Rezoning Transportation Analysis

Petition Number: 2020-052

General Location Identifier: Tax ID 15101603

Date	Description
4/20/20	First Review

STREET CROSS SECTION
PETITION #2020-052
FOR
EAST BOULEVARD OFFICE
1312,1318, 1324 EAST BOULEVARD
CHARLOTTE, NORTH CAROLINA 28203

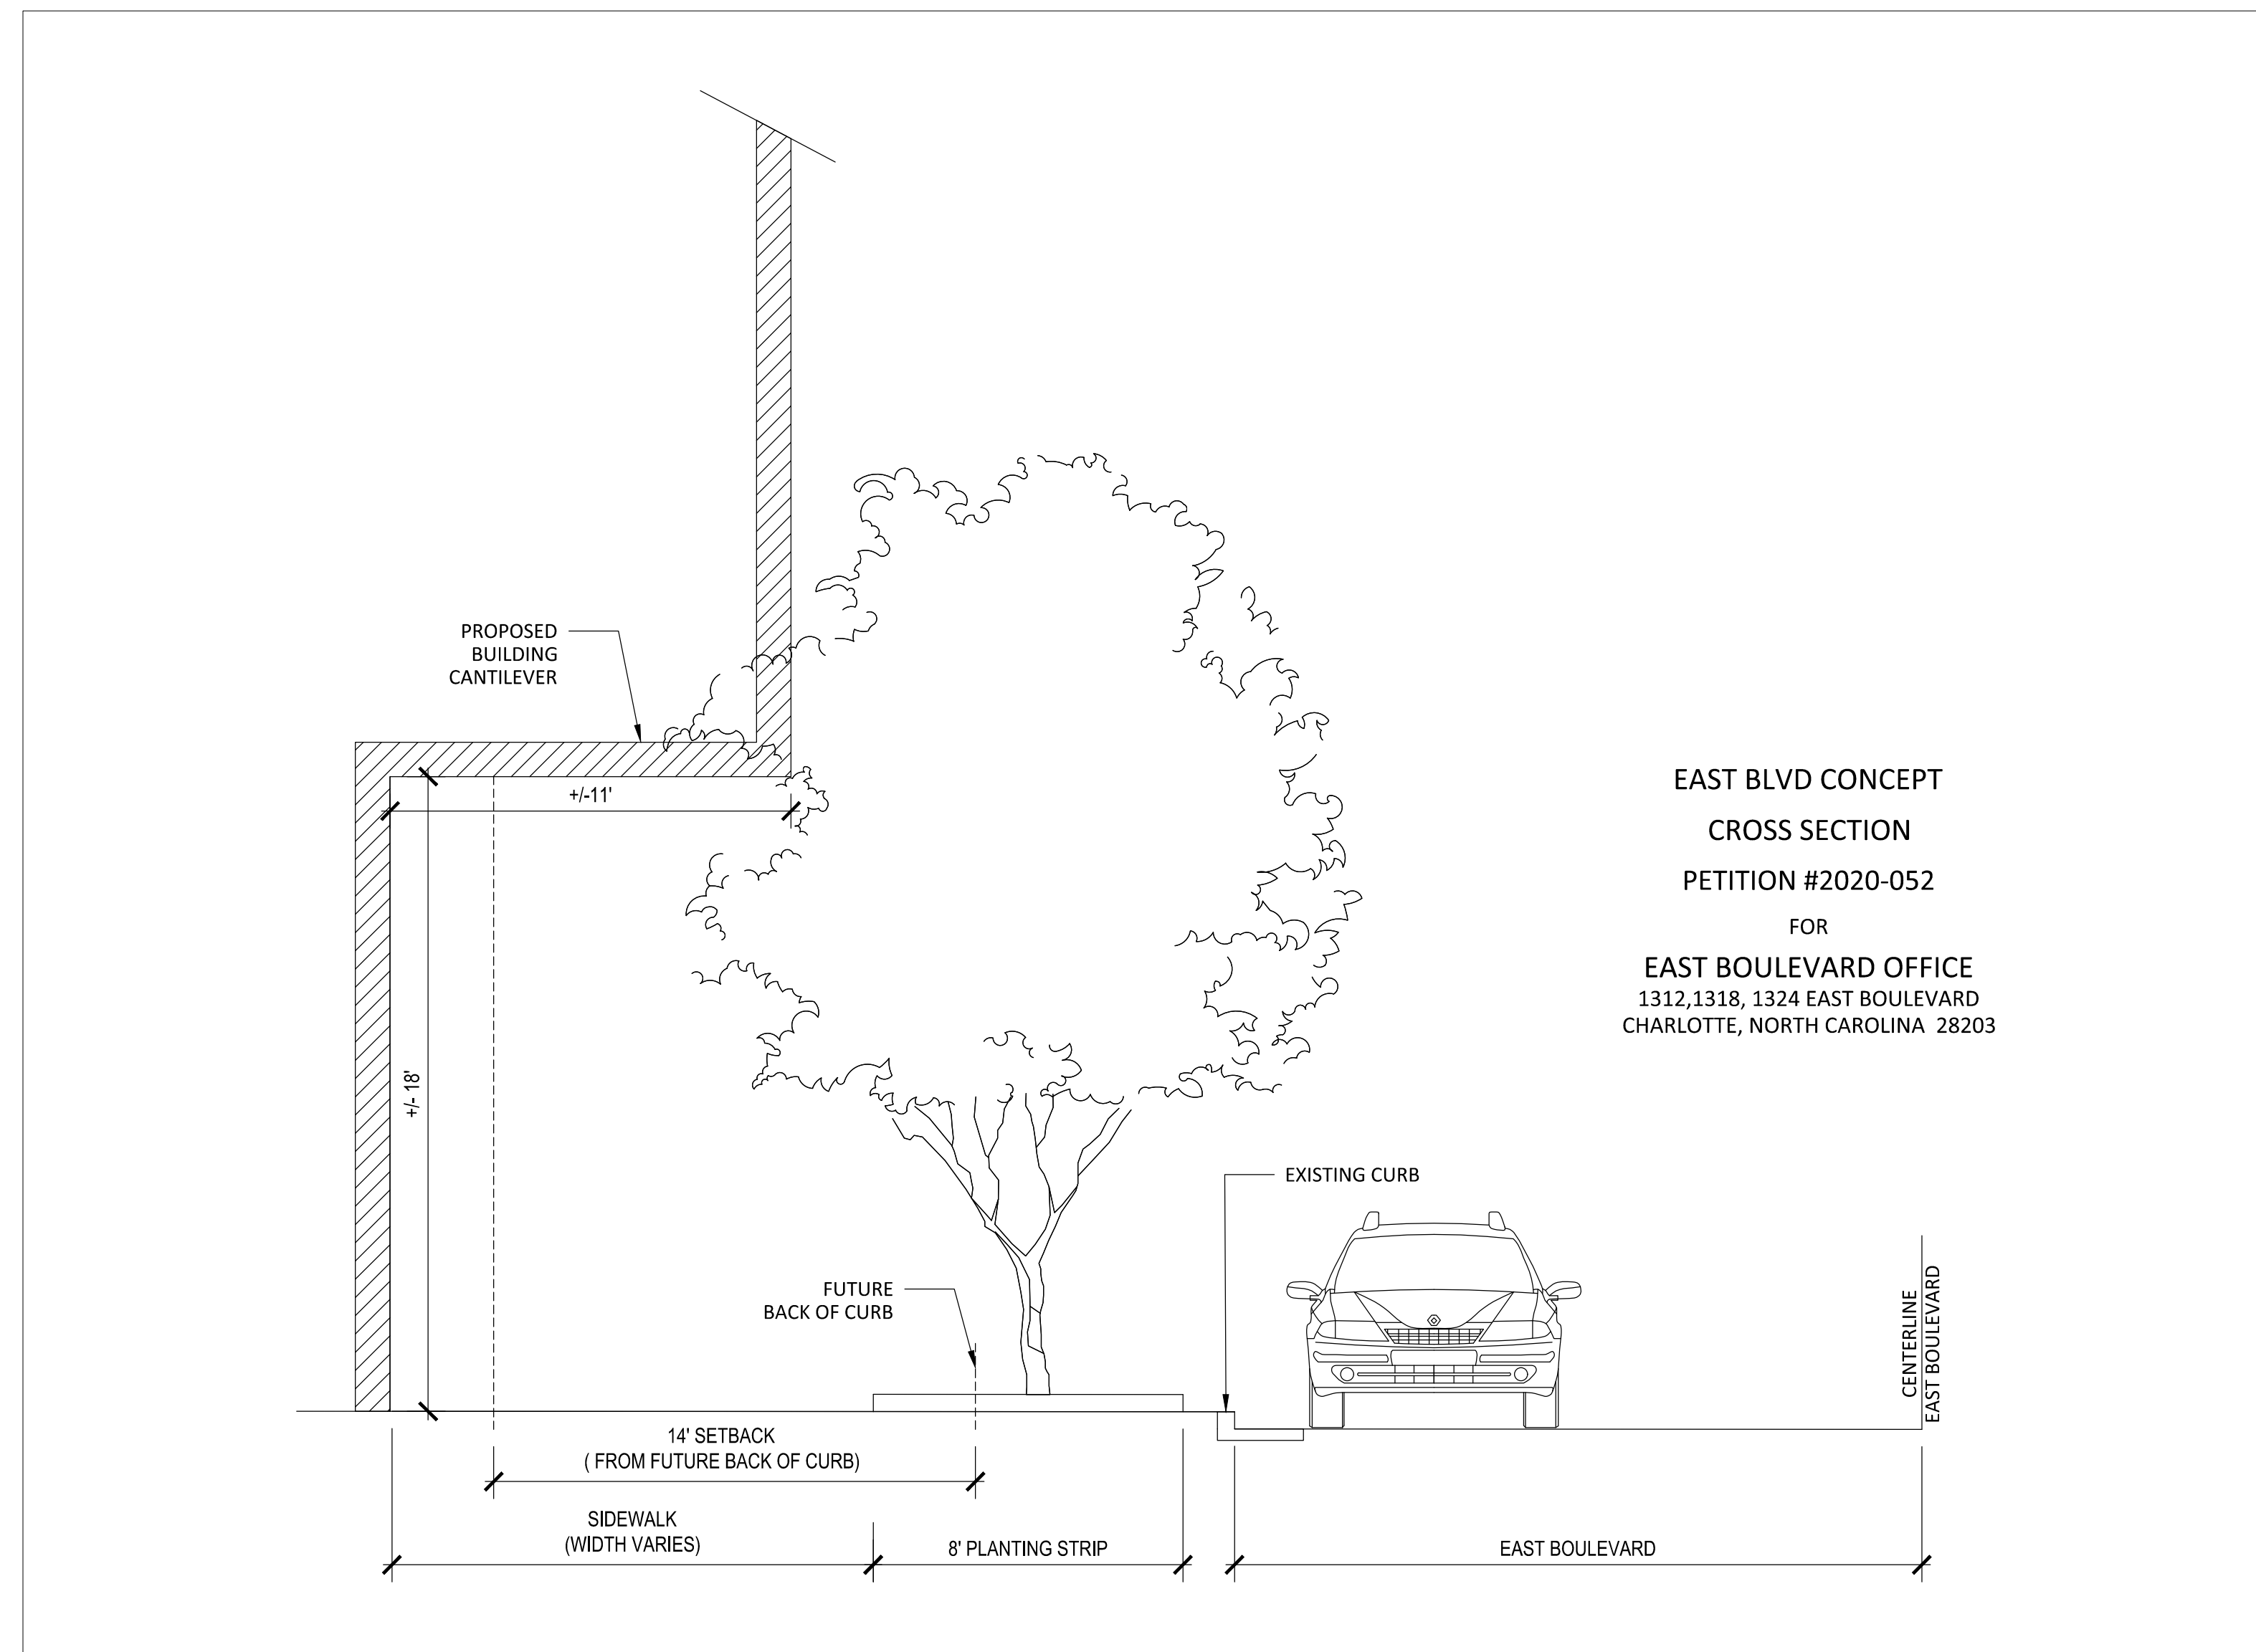
1. **Curbline** The proposed zoning district has a setback measured from back of the existing or proposed future curbline.
 - a. **Scott Ave.:** The future location of curb and gutter is in its existing location.
 - b. **East Blvd.:** The proposed curbline and setback need to be revised from what is shown on the site plan. The East Blvd. Pedscape Plan (2002) prescribes a 54-foot back-of-curb (BOC) to back-of-curb dimension with a 12-foot setback. However, this plan predates the East Blvd. Road Diet (circa 2005), the Urban Street Design Guidelines, Charlotte WALKS, and Charlotte BIKES. After considering all of these plans, the future curbline should be 55 feet BOC-BOC (27.5 feet centerline to BOC) with a 14-foot setback:
 - Four 10-foot vehicle lanes
 - Two 5-foot standard bike lanes
 - Two 2.5-foot curbs and gutters
 - Two 14-foot hardscape setbacks

The petitioner should revise the site plan should show the curb and gutter labeled and dimensioned from the centerline for each road. The petitioner may move the curbline as described or provide additional hardscape (with trees in tree pits corresponding to their future location).

DEVELOPMENT STANDARDS
Petitioner: Selwyn Property Group, Inc.
Rezoning Petition No. 2020-xx
3/9/2020

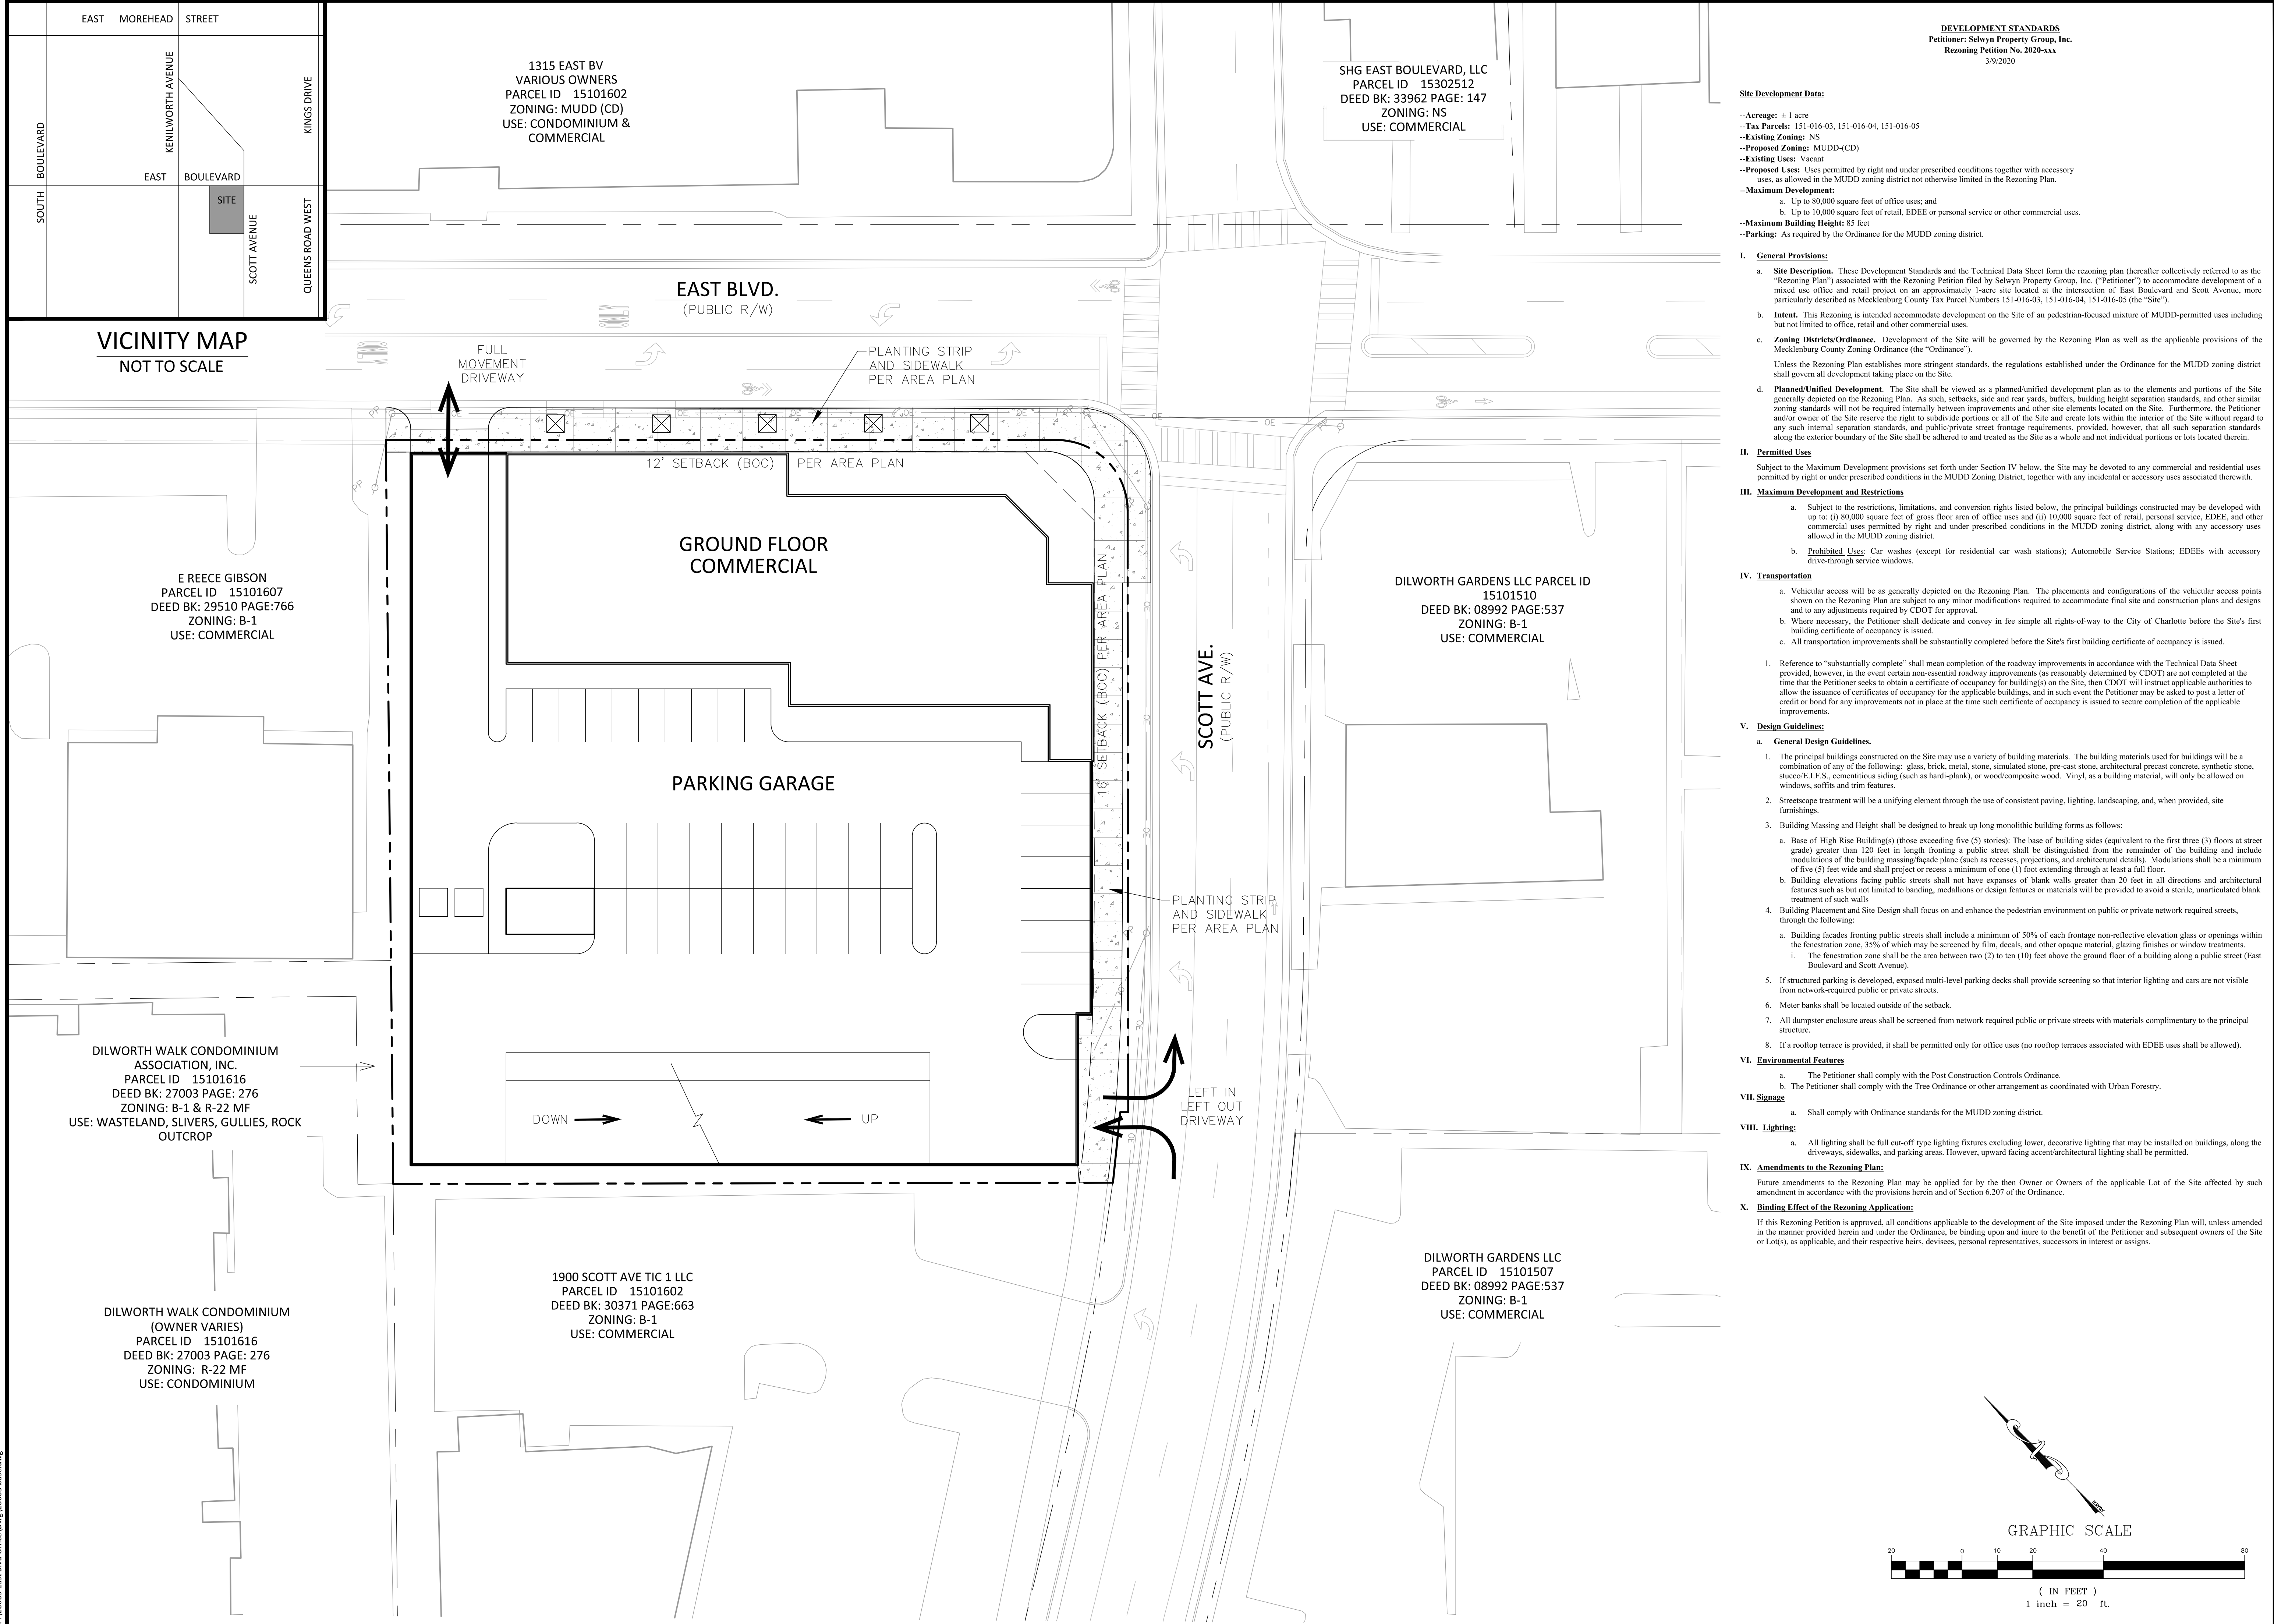
The site is located on the southwest corner of the signalized intersection of East Blvd./Scott Ave. in the commercial core of Dilworth. The petitioner should revise the site plan to meet the ordinance requirements and the outstanding items listed below.

3. The proposed driveway to East Blvd. needs to be a one-way in-only driveway, matching what has been built at the site across East Blvd. The parking deck needs to accommodate the on-site servicing of dumpsters and circulation of SU-30 vehicles to Scott Ave.

4. The petitioner should revise the site plan to add a note specifying dedication and fee simple conveyance of all rights of way to the City before the site's first building certificate of occupancy is issued. CDOT requests right of way set at 2' behind back of sidewalk, or to face of building, as appropriate.
